Project Name: Evolution Rock and Fitness

Address: 65 WARREN AVE

To: FILE
From: Jean Fraser
Subject: Application ID: 2013-163
Date: 8/9/2013

Evolution Rock and Fitness, LLC -Level III - Site Plan Application
Staff Review Comments, dated July 19, 2013

SITE PLAN
 OF:
EVOLUTION ROCK & FITNESS, LLC.
 66 WARREN AVENUE
 PORTLAND, MAINE
 FOR:
EVOLUTION ROCK & FITNESS, LLC.
 P.O. BOX 22
 CONCORD, NH 03302

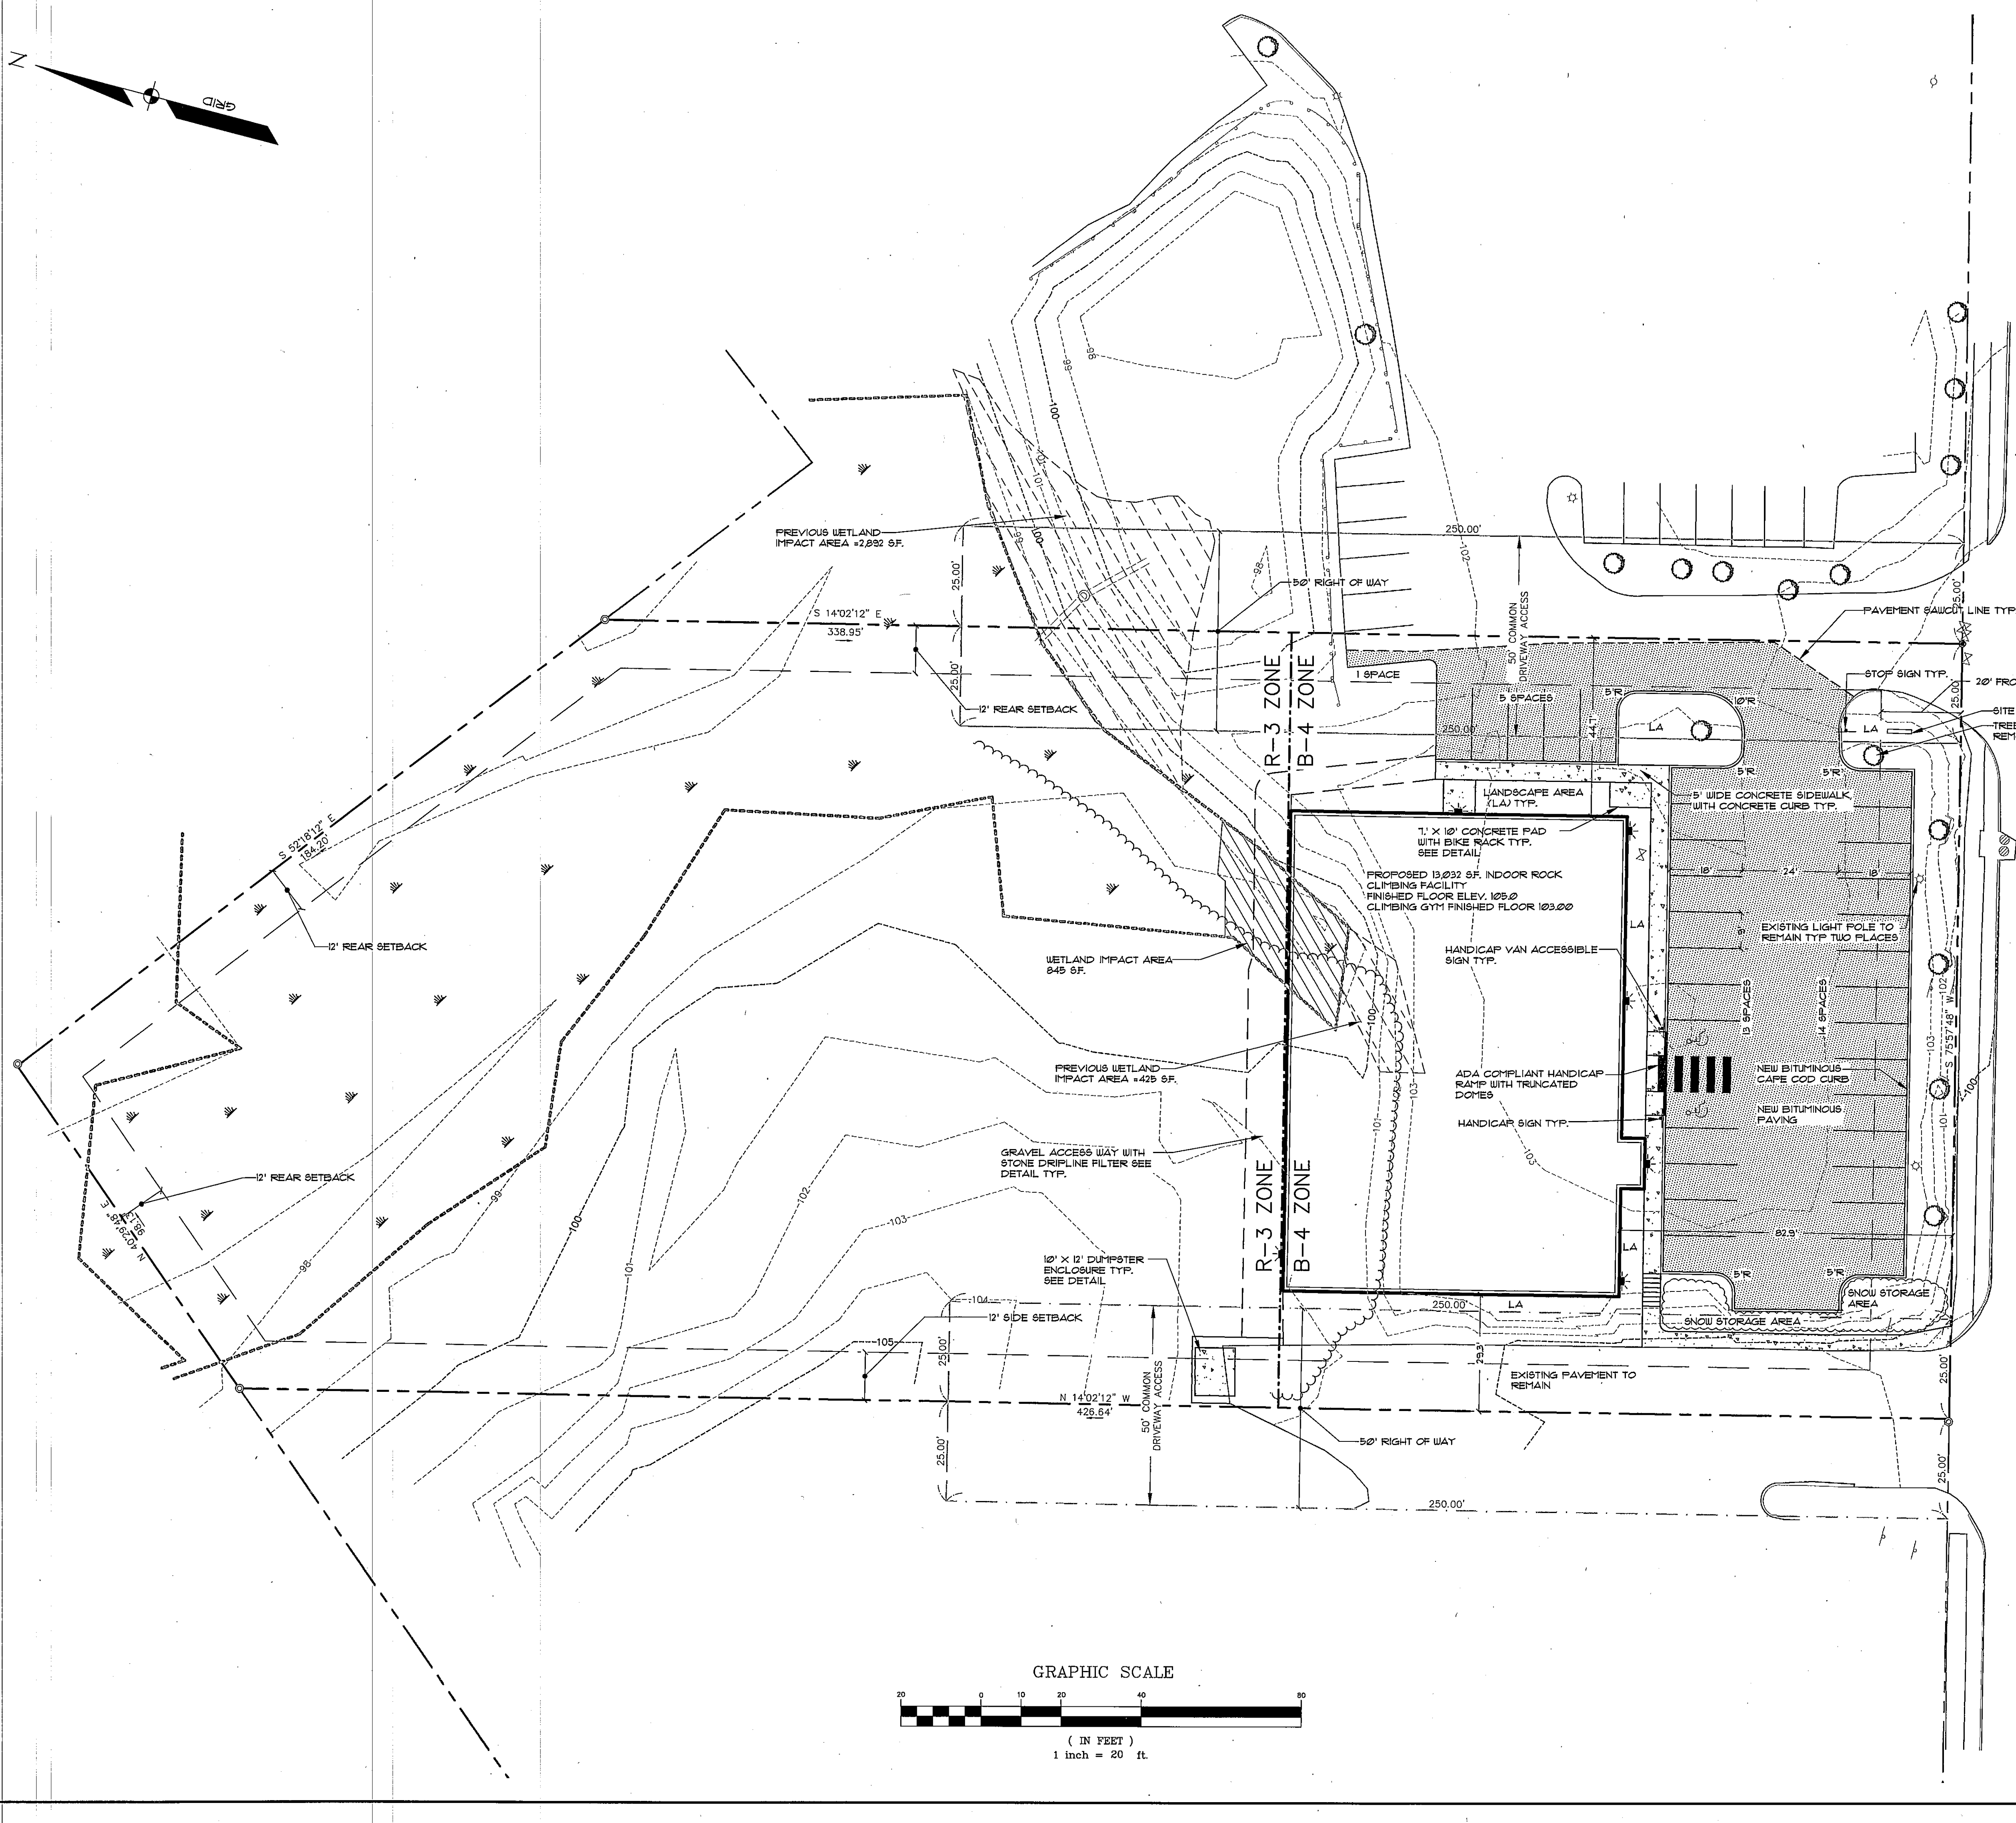
The applicant has confirmed that the entrance to the new building is at a front door accessed by a sidewalk immediately in front of the building. The Traffic Engineering Reviewer has commented that a "pedestrian connection between the building and the sidewalk on Warren Avenue shall be provided" (Attachment 3); this is a requirement of the Site Plan ordinance.

A pedestrian connection between the building and the sidewalk has been added to the west side of the building.

GRADING AND UTILITY PLAN
OF:
EVOLUTION ROCK & FITNESS, LLC.
65 WARREN AVENUE
PORTLAND, MAINE
FOR:
EVOLUTION ROCK & FITNESS, LLC
P.O. BOX 22
CONCORD, NEW HAMPSHIRE 03302

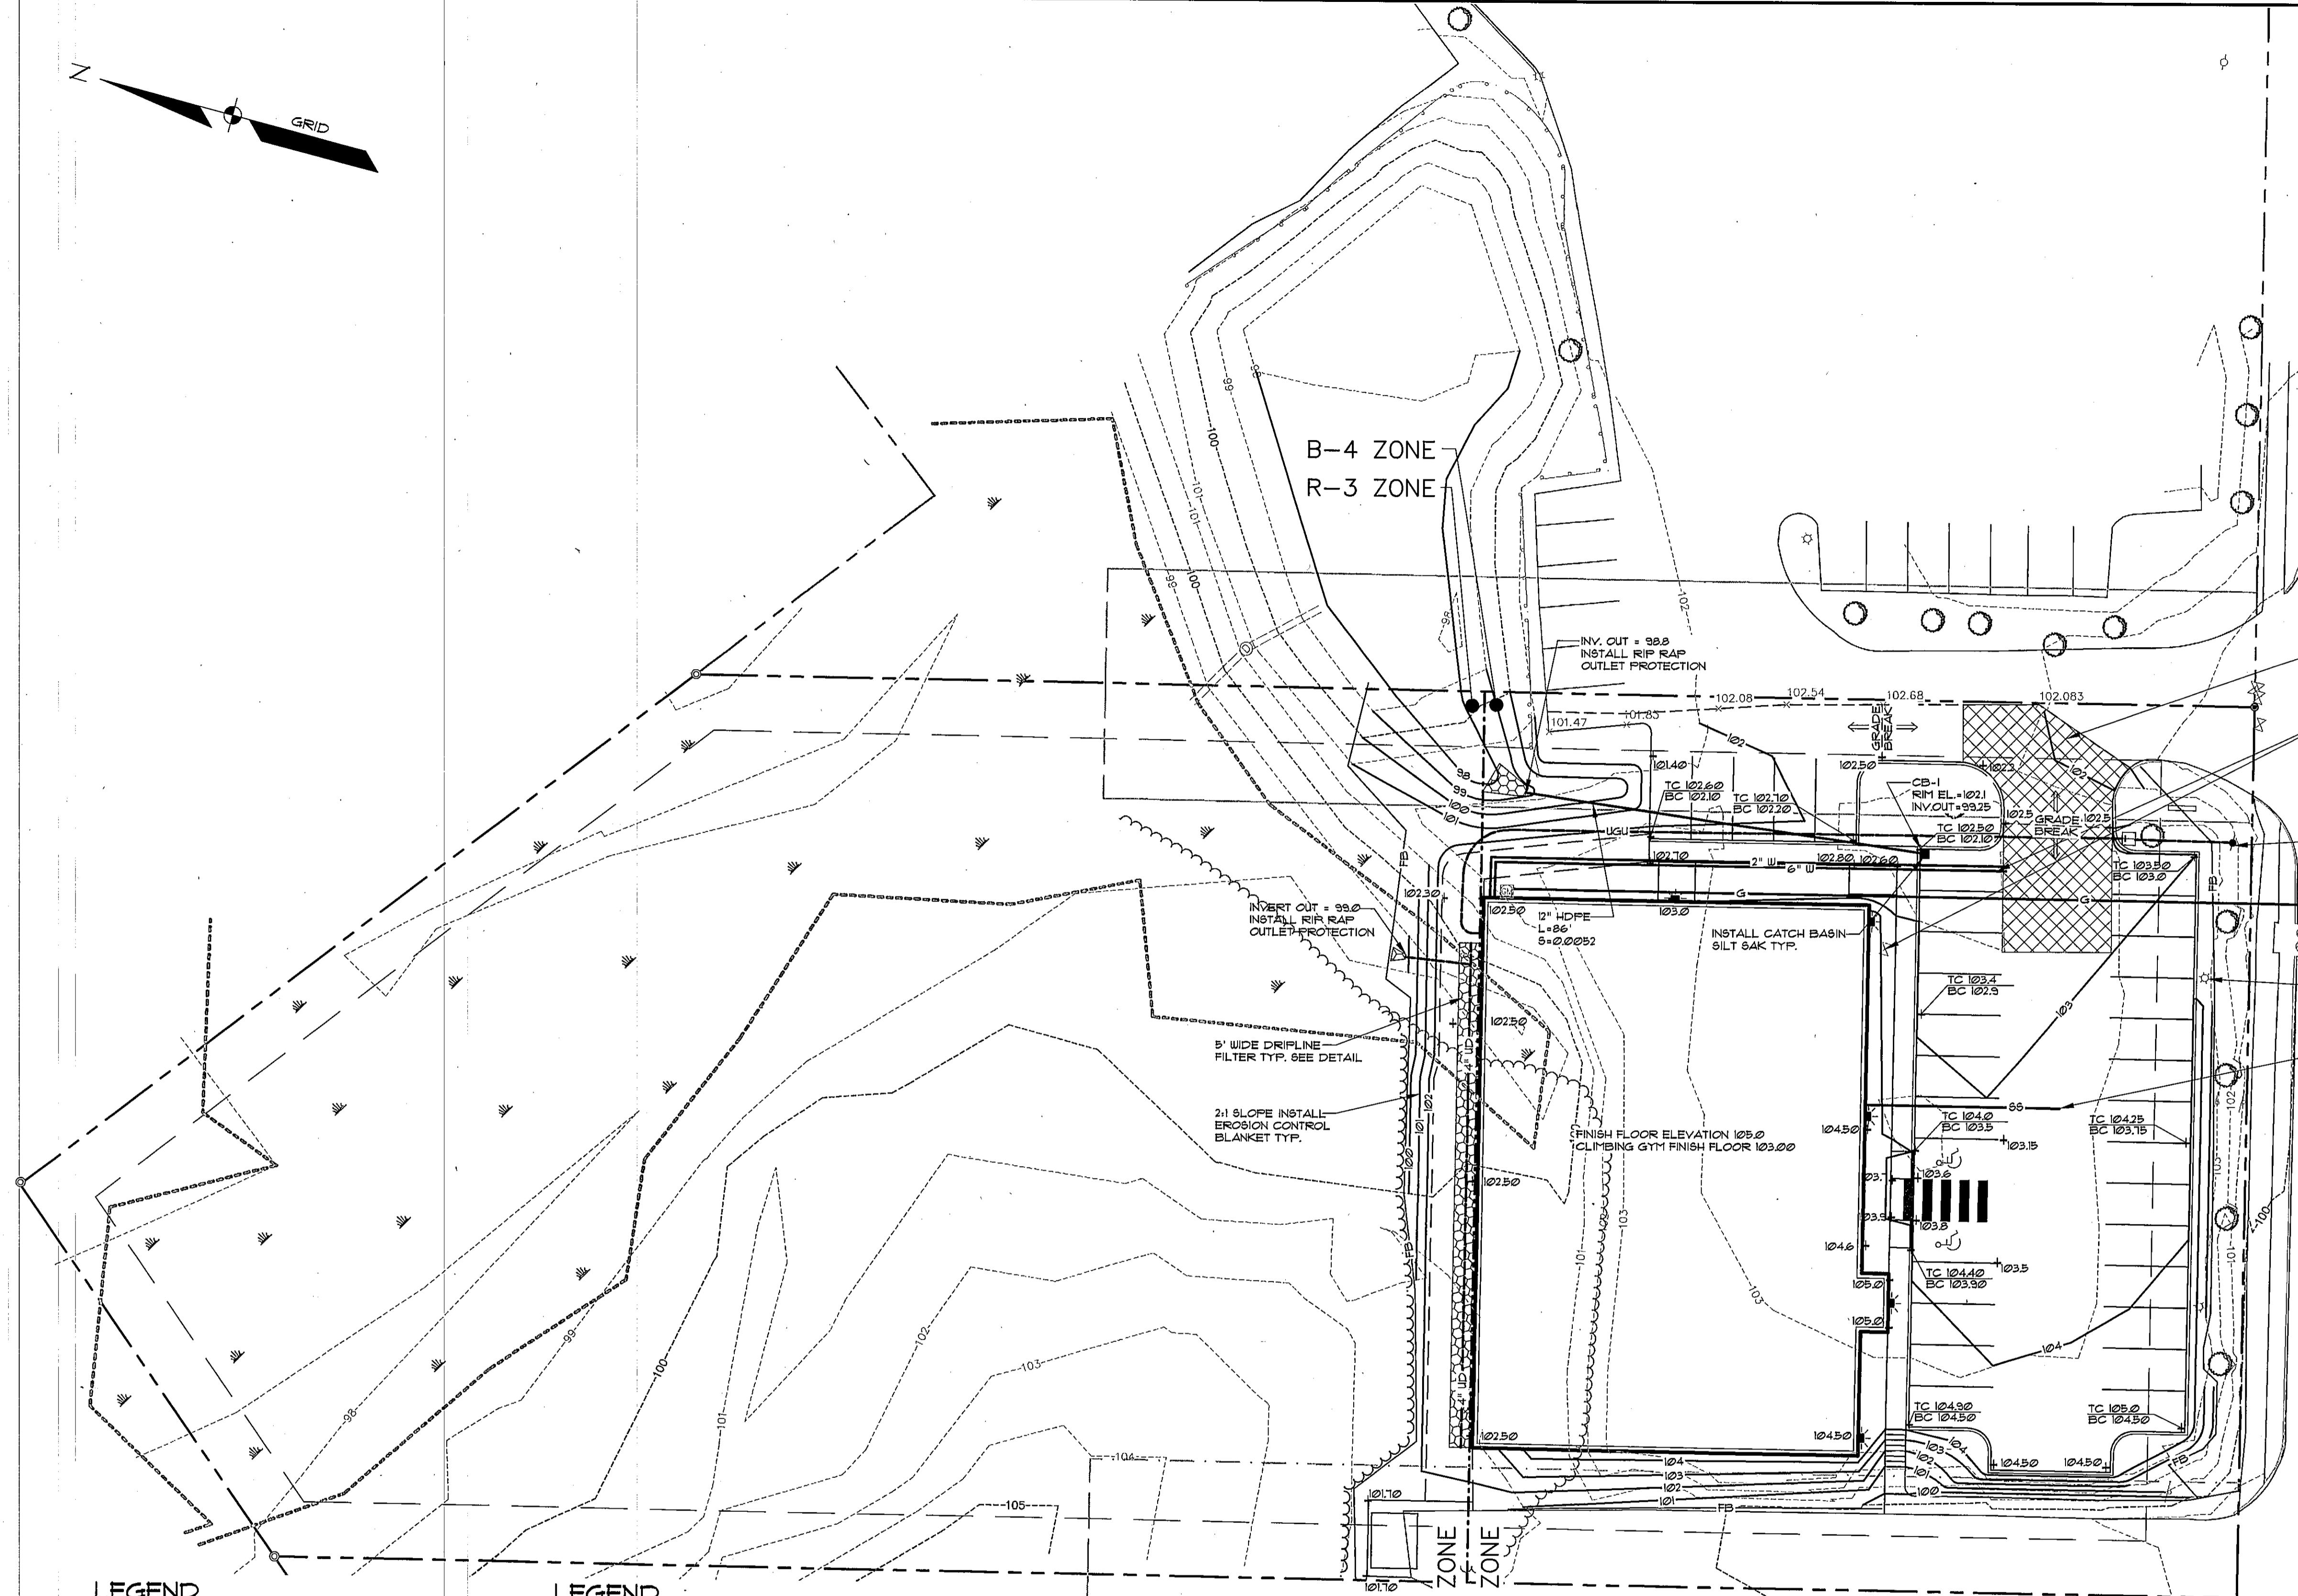
The property is B-4 at the front (south) of the site and zoned R-3 at the rear of the site. The rear edge of the parking lot is about 350 feet from the lot boundary furthest from Warren Avenue; the R-3 zone line is 100 feet from the rear edge of the existing parking lot. Although the zone line is not included in the Site Plan (Plan 4) it appears that all of the proposed disturbance to the site is within the B-4 zone. In any case the ordinance allows some encroachment in the R-3 zone as follows:

The proposed building and parking lot are within the B-4 zone and are some 90-100 feet south of the R-3 zone line. The Ordinance Section 14-51 allows development to encroach on the R-3 zone as described below, although the project before the Board does not make use of this provision (see Attachment 2):

We have added the zone line to the Grading and Utility Plan (Sheet 4) .
